CITY OF PORTLAND, MAINE

PLANNING BOARD

RE: Proposed Ballpark Drive Subdivision
ID #2004-0028, CBL #371 A002001

On September 21, 2004 the Portland Planning Board voted unanimously (6-0, Patterson absent) to approve the Ballpark Drive Subdivision in the vicinity of Washington Avenue and Riverside Street, with the following conditions:

SHEET TITLE:	PLAN OF DIVISION OF LAND THE HAVERTY ESTATE PROPERTY BALLPARK DRIVE SUBDIVISION	SHEET 1 OF 10
SCALE:	1" = 100'	DATE: SEPTEMBER 3, 2004
		DRAWING NO.: 1

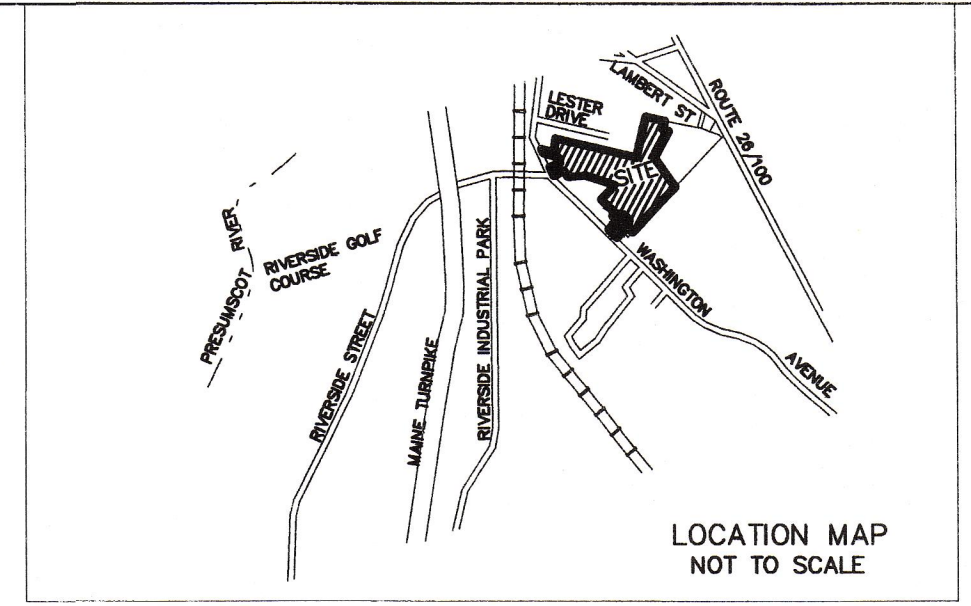
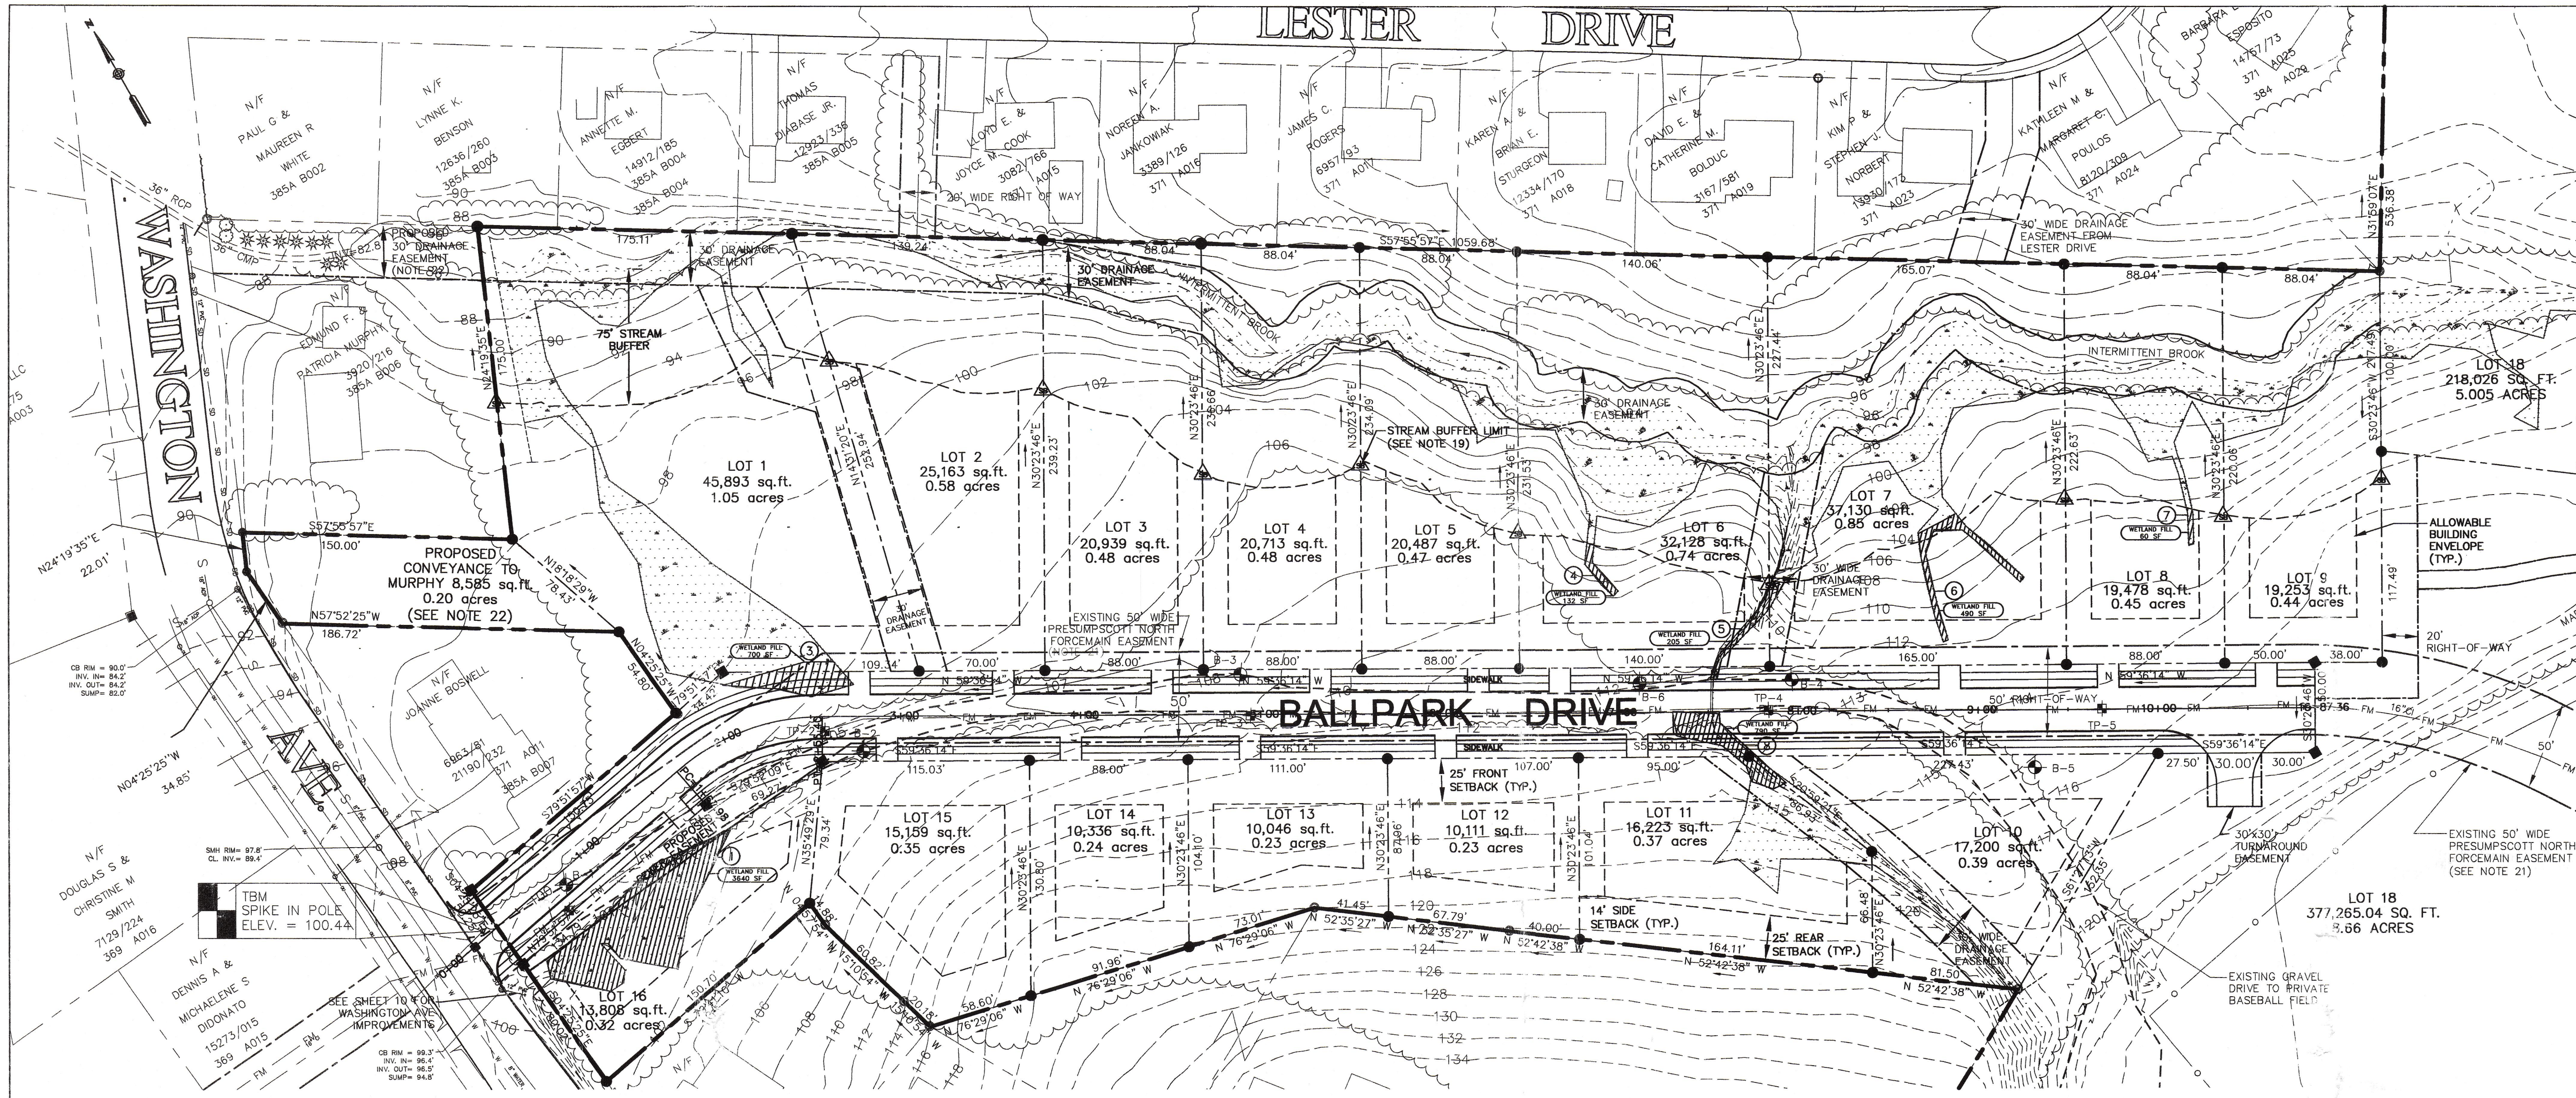
- ii. The applicant shall remove from the plans the 10 foot wide trail easement shown across lot 17 and replace it on the plans with a 20-foot wide trail easement which shall link the Ballpark Drive right of way with the Grace Baptist Church property across lot 18 so as to facilitate an eventual through connection to Lambert Street in coordination with Portland Trails and subject to review and approval by the Planning Authority.

viii. Lot 18 as shown on sheet 1 of the plan set dated September 3, 2004 shall be conserved in perpetuity by deed restriction, conveyance to an approved land trust, or by other legal mechanism subject to final review and approval by Corporation Counsel.

ix. The applicant shall submit revised plans with a 50 foot wide panhandle added to lot 18 so as to provide that lot with its required 50 feet of street frontage onto Ballpark Drive.

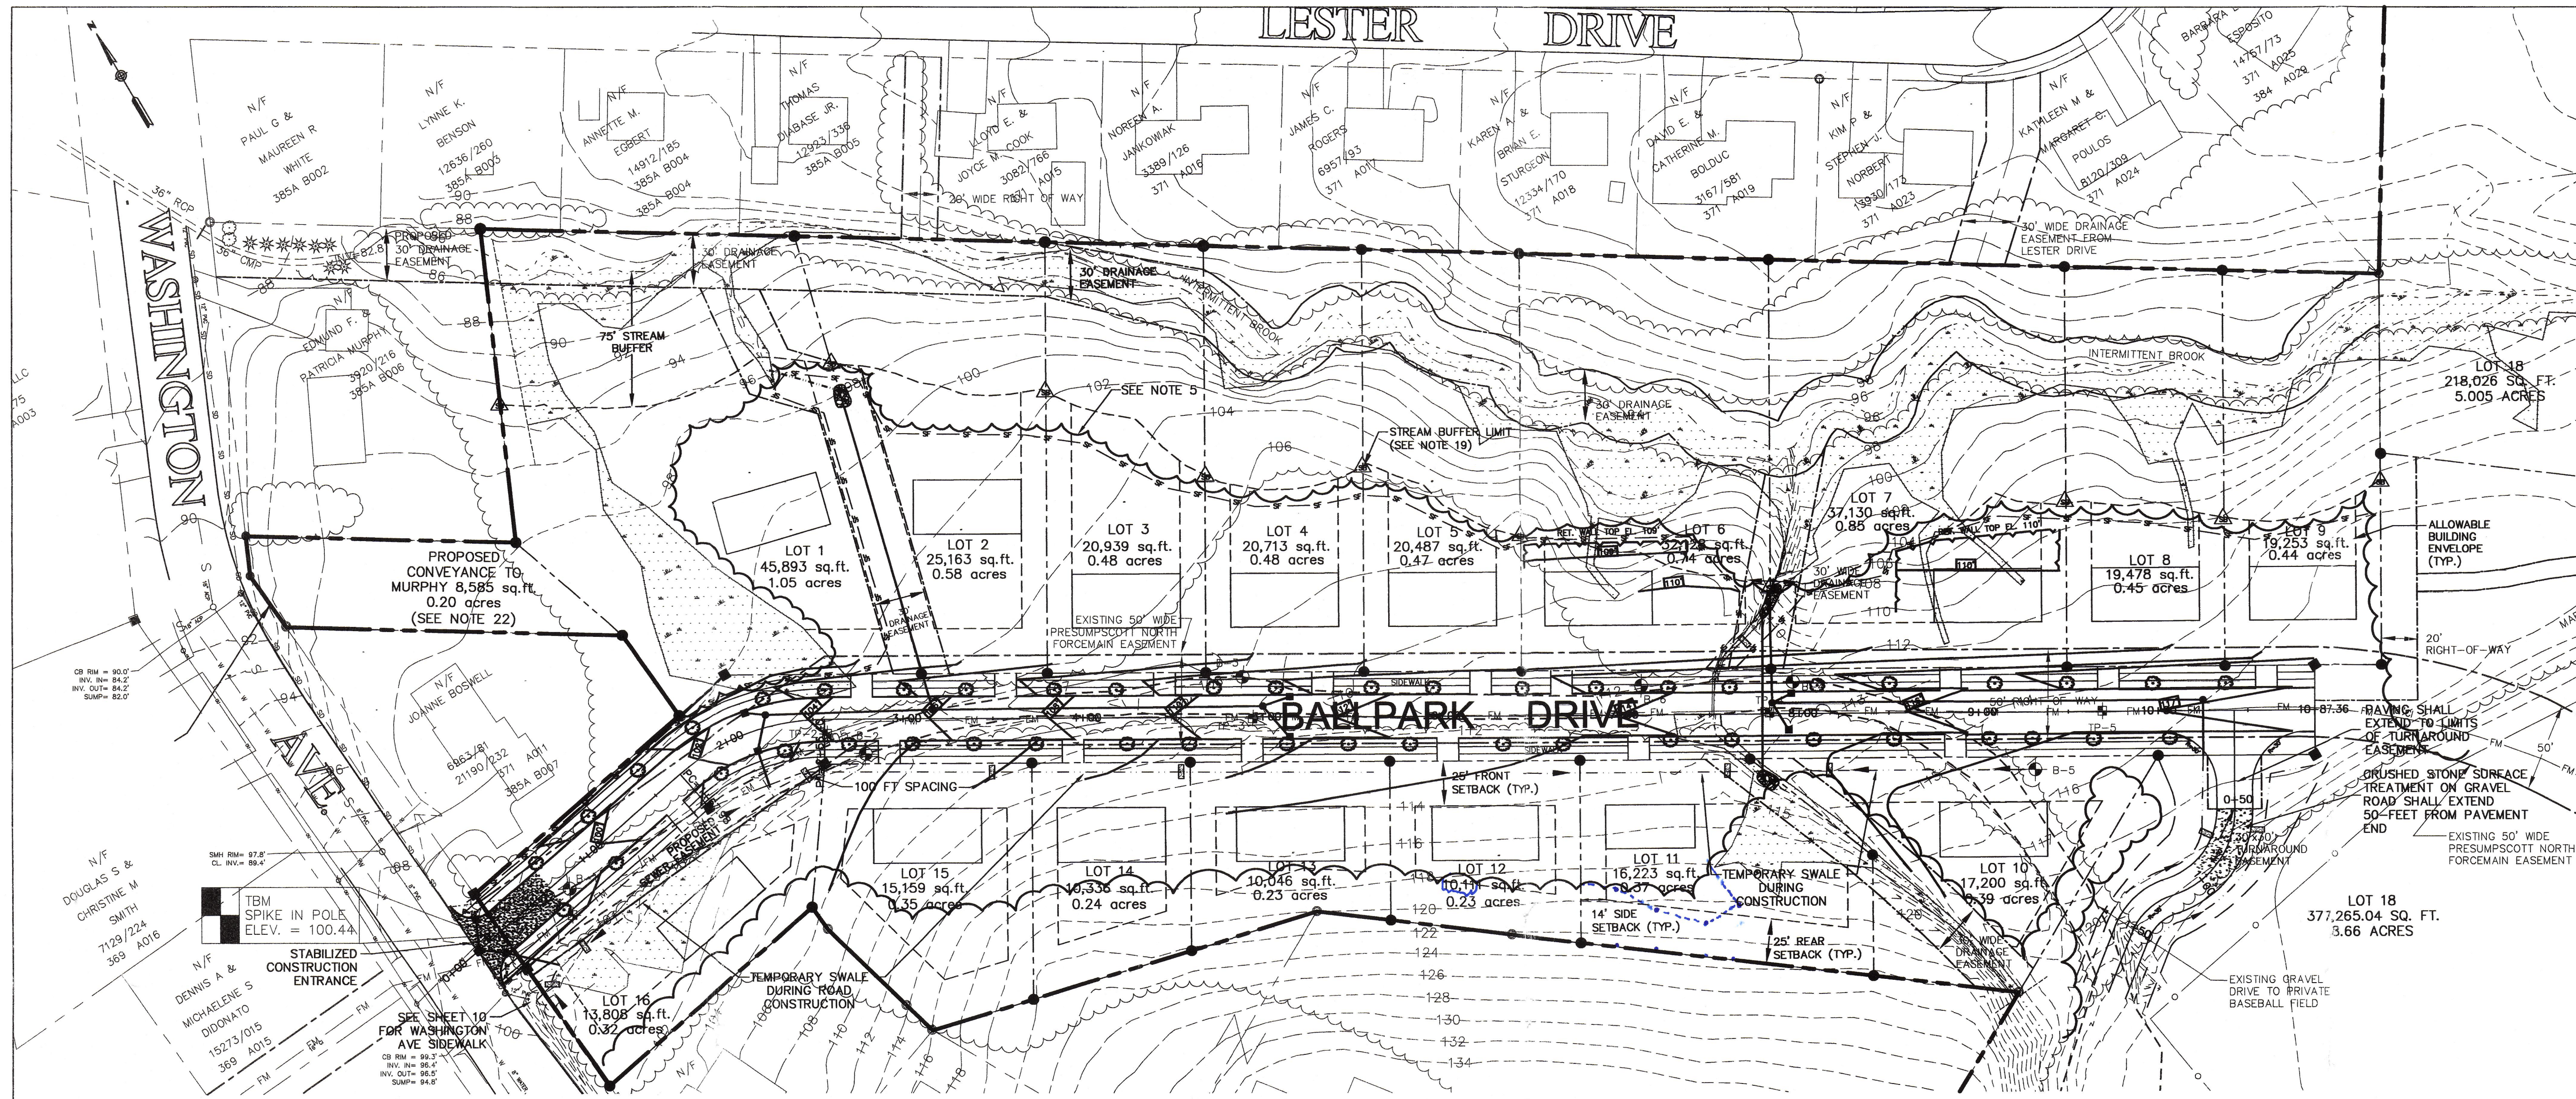
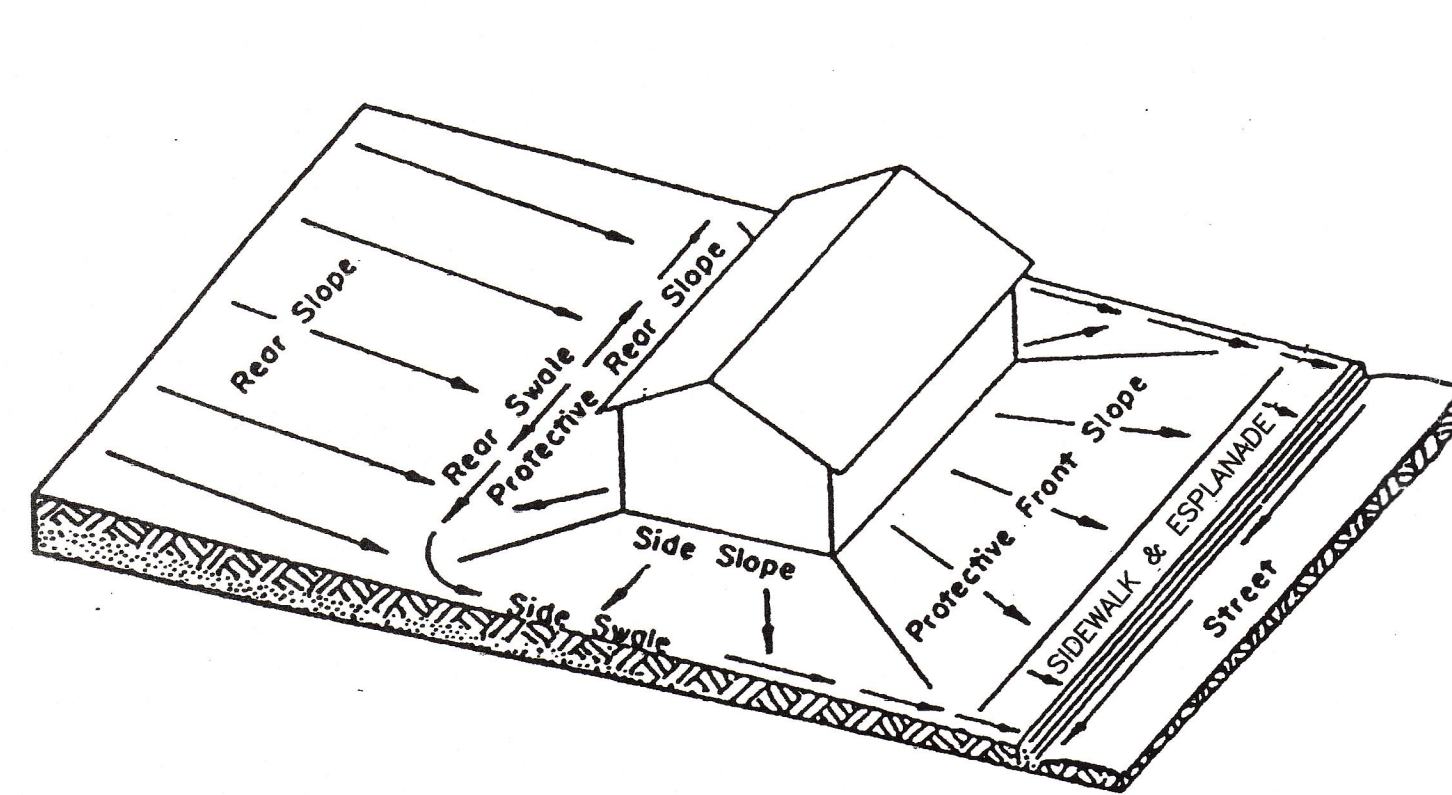
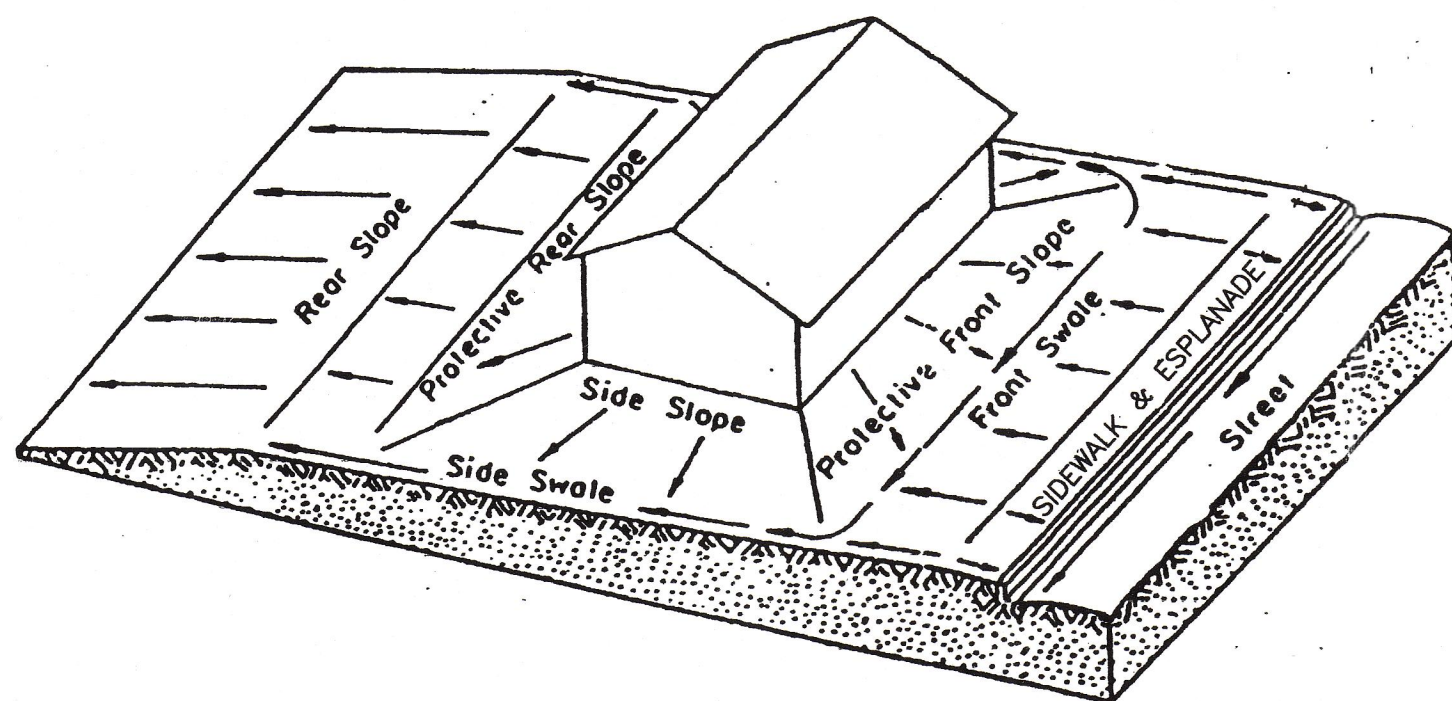
- iii. The 75 foot no-disturbance stream buffer across the backs of lots 1-9 shall be field located by a surveyor and physically marked where it intersects property lines. The marker design specification shall be subject to final review and approval by the planning authority.

- iv. The proposed street tree installation plan shall be subject to final review and approval by the City Arborist and the Planning Authority.
- v. The proposed improvements to the Washington Avenue / Riverside Street and Washington Avenue / Ballpark Drive intersections shall be subject to final review and approval by the City's traffic division.
